# Sea Link

Document 7.4.11: Draft Statement of Common Ground Between National Grid Electricity Transmission and the Port of London Authority.

Planning Inspectorate Reference: EN020026

Version: B  
November 2025

Plate 1.1 Areas of Safeguarded Water Depth

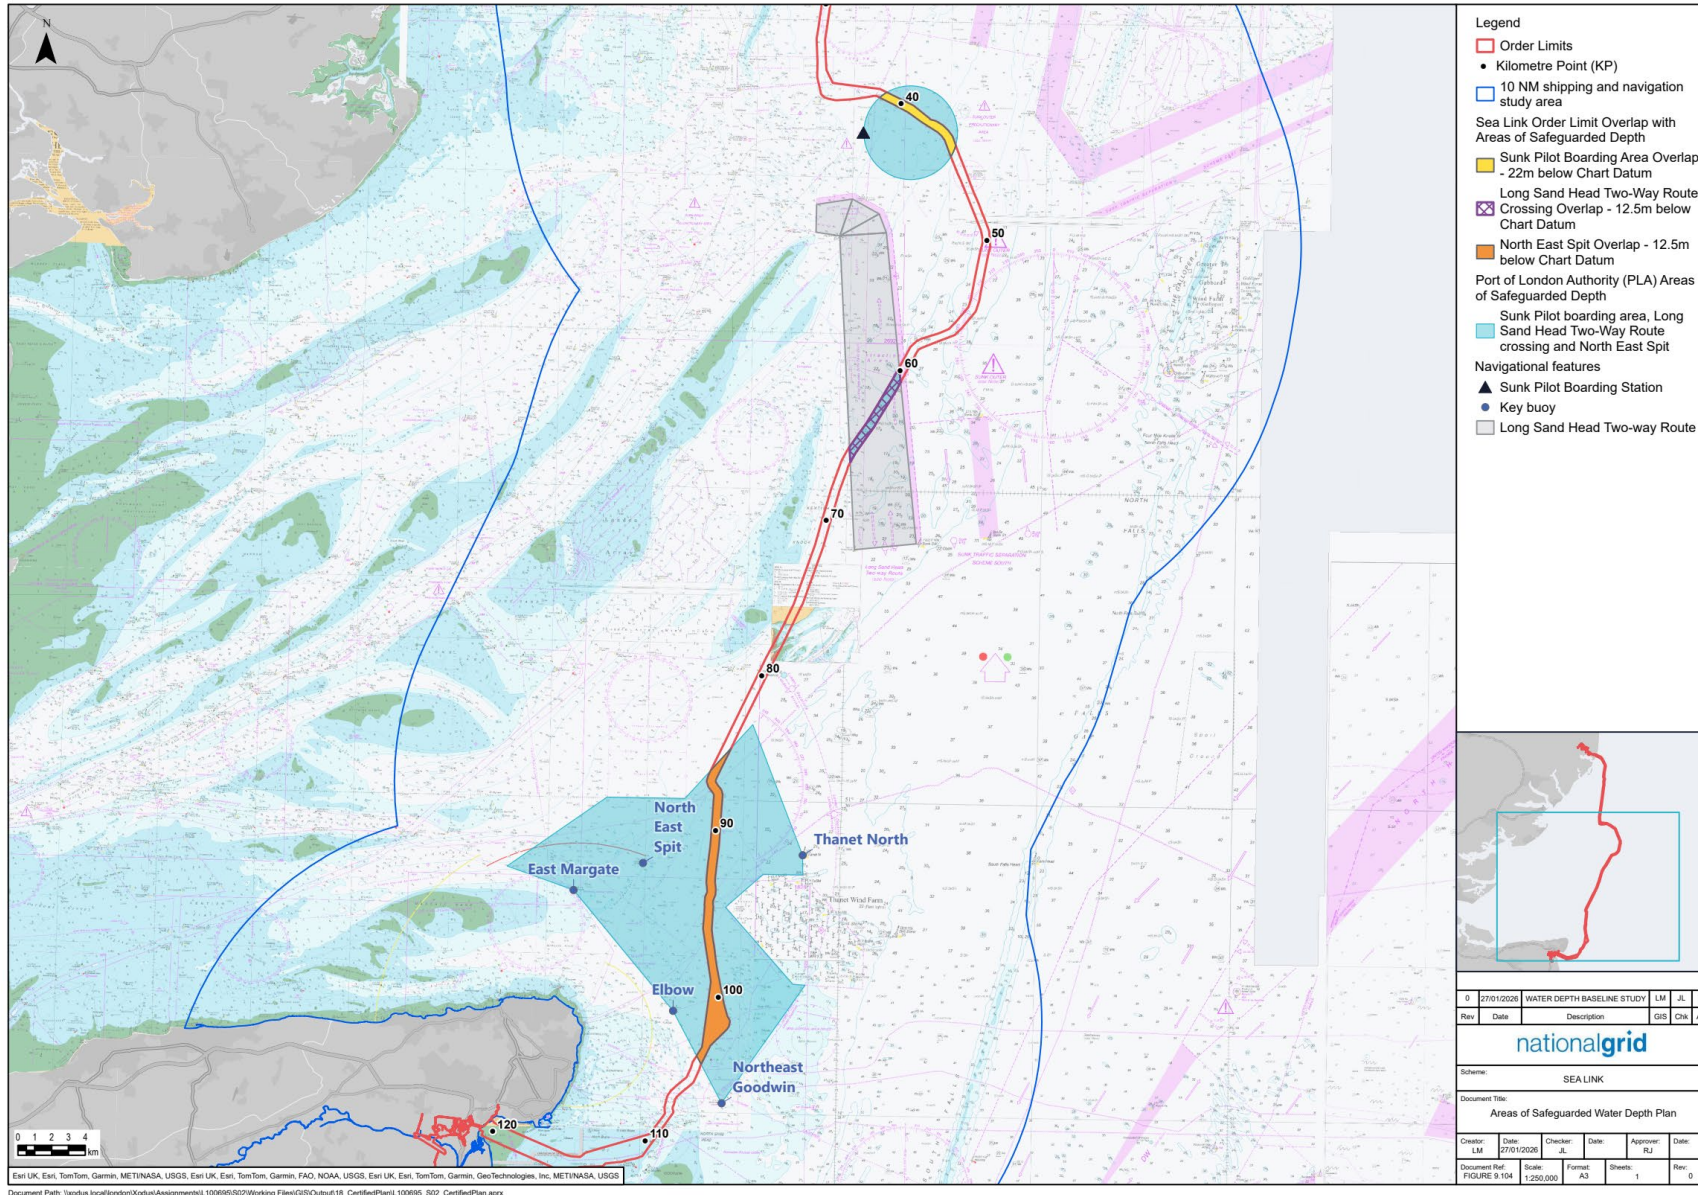
| Ref   | Relevant Application Document                                                     | Summary of Description of Matter | PLA Current Position                                                                                                                                                                                                                                                                                                                                                                                                                                                                                                                                                                                                                                                                                                                                                                                                                                                                                                                                                                                                                                                                                                                                                                                                                                                                                                                          | The Applicant’s Current Position                                                                                                                                                                                                                                                                                                                                                                                                                                                                                                                                                                                                                                                                                                                                                                                                                                                                                                                                                                                                                                                                                                                                                                                                                                                                                                                                                                                                                                                                                                                     | Status           |
|-------|-----------------------------------------------------------------------------------|----------------------------------|-----------------------------------------------------------------------------------------------------------------------------------------------------------------------------------------------------------------------------------------------------------------------------------------------------------------------------------------------------------------------------------------------------------------------------------------------------------------------------------------------------------------------------------------------------------------------------------------------------------------------------------------------------------------------------------------------------------------------------------------------------------------------------------------------------------------------------------------------------------------------------------------------------------------------------------------------------------------------------------------------------------------------------------------------------------------------------------------------------------------------------------------------------------------------------------------------------------------------------------------------------------------------------------------------------------------------------------------------|------------------------------------------------------------------------------------------------------------------------------------------------------------------------------------------------------------------------------------------------------------------------------------------------------------------------------------------------------------------------------------------------------------------------------------------------------------------------------------------------------------------------------------------------------------------------------------------------------------------------------------------------------------------------------------------------------------------------------------------------------------------------------------------------------------------------------------------------------------------------------------------------------------------------------------------------------------------------------------------------------------------------------------------------------------------------------------------------------------------------------------------------------------------------------------------------------------------------------------------------------------------------------------------------------------------------------------------------------------------------------------------------------------------------------------------------------------------------------------------------------------------------------------------------------|------------------|
| 3.1.1 | Application Document 6.3.4.7.A ES Appendix Navigational Risk Assessment [APP-203] | Water depth                      | <p>The Consultee expressed concerns surrounding any reduction in water depth in the deep water channels and in the long sand head two way route.</p> <p>The proposed marine route is running close to the northeast spit boarding and landing diamond and there must be no reduction in water depths in this area. The area of boarding and landing is not limited to the diamond but takes place depending on weather and other traffic. GridLink runs close to Elbow Buoy, where water depth is also critical. Boarding and landing can also take place in the vicinity of the Elbow Buoy. Container ships can sometimes come through here, using Northeast Spit/Elbow. Where it is shallower, further south, there are less concerns as ships don’t navigate through this area.</p> <p>In terms of dredging, there are plans to increase access depths. The Consultee want to maximise their opportunities for large vessels, but future trade is not completely known, so it is a balance to future proof.</p> <p>Water depth needs to be safeguarded at the deep-water routes. Consensus is that access needs to be safeguarded for vessels of 20m draft, and accounting for 10% under keel clearance that means that -22 m CD needs to be safeguarded. Five Estuaries and North Falls have agreed this is realistic future scenario</p> | <p>Impacts of potential reduction in water depth is discussed in <b>Application Document 6.3.4.7.A ES Appendix Navigational Risk Assessment [APP-203]</b>.</p> <p>The Applicant has provided the latest Order Limits to the Consultee (in July 2022 and again in December 2024) .</p> <p>Regarding Deep Water Routes, the Applicant can confirm that unlike the Five Estuaries and North Falls projects, the Sea Link cable route will not interact with the deep water routes “Sunk deep water route” or “Trinity deep water route”.</p> <p>Regarding a GridLink cable crossing, the Applicant’s current position is that a co-engineered solution would be designed which minimises the height of rock berms/protection structures but maintains required protection levels.</p> <p>The Applicant acknowledges the Consultee’s point about needing to provide clarity and confidence surrounding long term access to the Port of London and seeks to engage further with the Consultee to provide assurance on this matter and provide greater clarity.</p> <p>The Applicant understands the Consultee’s position on facilitating current and future access to and from the port and has received the Consultee’s geographical information system (GIS) data of the three areas of safeguarding water depth (Sunk pilot boarding station area, Long Sand Head Two Way Route crossing area, and NE Spit area).</p> <p>The Applicant has been working with the Consultee to understand areas where the Consultee wishes to safeguard water depth</p> | Under discussion |

| Ref   | Relevant Application Document | Summary of Description of Matter | PLA Current Position                                                                                                                                                                                                                                                                                                                                                                                                                                                                                                                                                                                                                                                                                                                                                                                                                                                                                                                                                                                                                                                                                                                                                                                                                                                | The Applicant's Current Position                                                                                                                                                                                                                                                                                                                                                                                                                                                                                                                                             | Status           |
|-------|-------------------------------|----------------------------------|---------------------------------------------------------------------------------------------------------------------------------------------------------------------------------------------------------------------------------------------------------------------------------------------------------------------------------------------------------------------------------------------------------------------------------------------------------------------------------------------------------------------------------------------------------------------------------------------------------------------------------------------------------------------------------------------------------------------------------------------------------------------------------------------------------------------------------------------------------------------------------------------------------------------------------------------------------------------------------------------------------------------------------------------------------------------------------------------------------------------------------------------------------------------------------------------------------------------------------------------------------------------|------------------------------------------------------------------------------------------------------------------------------------------------------------------------------------------------------------------------------------------------------------------------------------------------------------------------------------------------------------------------------------------------------------------------------------------------------------------------------------------------------------------------------------------------------------------------------|------------------|
|       |                               |                                  | <p>and are designing their scheme accordingly.</p> <p>The Consultee also requires 12.5 m for the southern access to the port (see also 3.1.7 Routeing below).</p> <p>Concern surrounding placing a constraint on the size of vessel that can enter the Port of London and therefore the capacity of the Port of London. The Sea Link application needs to provide clarity and confidence that long term access/egress to the Port of London would be maintained and that short term impacts during construction and maintenance would be kept to a minimum.</p> <p>The depth of the offshore cables are critical. In order to facilitate current and future access to and from the port the PLA needs to safeguard 22 m below chart datum for its northern approaches and 12.5 m below chart datum for its southern approaches. These water depths must therefore not be compromised in certain locations in order to facilitate access and egress for vessels over the life time of the project into and out of the Port of London. This means that there will be locations for example, at the Northeast Spit and at the Long Sand Head 2-way route where there cannot be a 5% reduction in water depth let alone a greater than 5% reduction in water depth.</p> | <p>to ensure long term access to the Port of London and will continue to do so through Examination with the goal of reaching agreement on this matter and minimising potential impacts.</p> <p>The Applicant is able to commit to safeguarding water depth to 12.5 m below Chart Datum within the PLA's Area of Safeguarded Depth 'Long Sand Head Two-Way Route crossing area', is continuing to engage with the Consultee in order to agree wording and terms of this commitment, and is also continuing engagement to come to an agreement in the remaining two areas.</p> |                  |
